Rights of Way

Julie Hall
Spatial Information Officer
Staffordshire County Council

Title: Landscape Masterplan

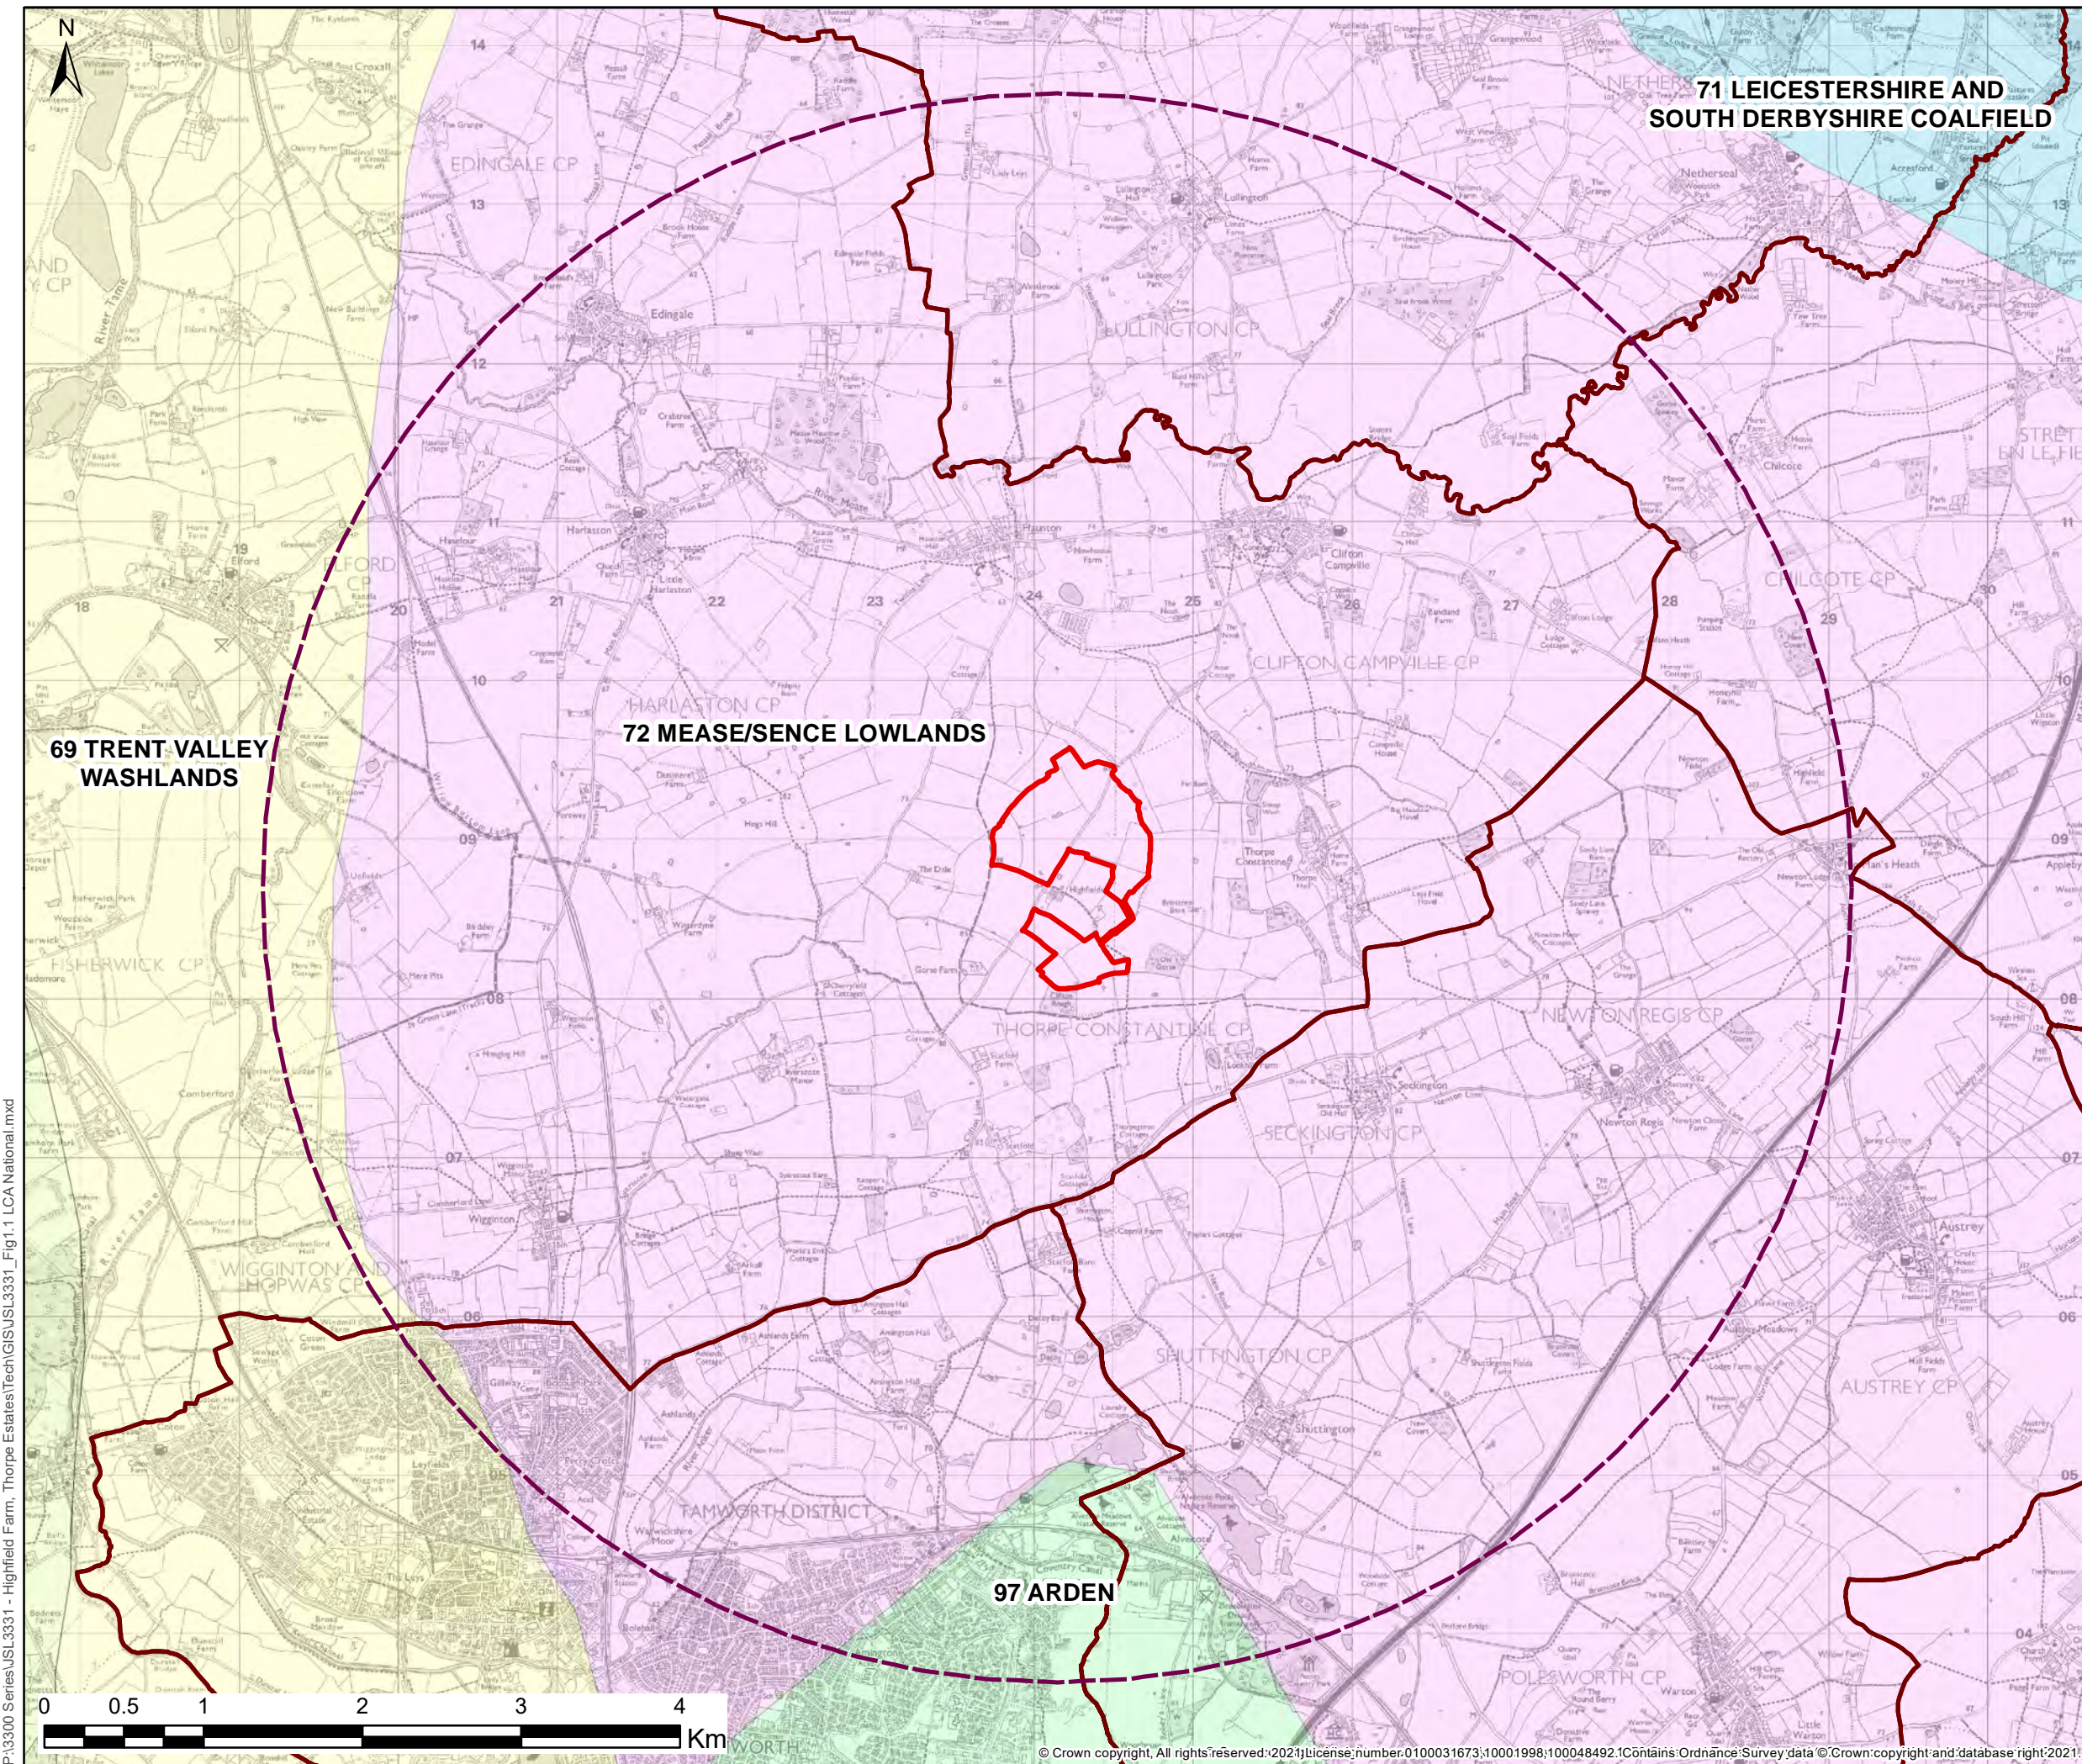
'The proposed development has been carefully designed with large offset buffers from the PRoW with proposed hedgerow, tree and shrub planting to further screen the development as well as the better management of existing vegetation to enhance the screening function in views from local PRoW.'

We would ask that trees/shrubs are not planted within 3 metres of the footpaths/bridleways unless the developer and any subsequent landowners are informed that the maintenance of the them is their responsibility.
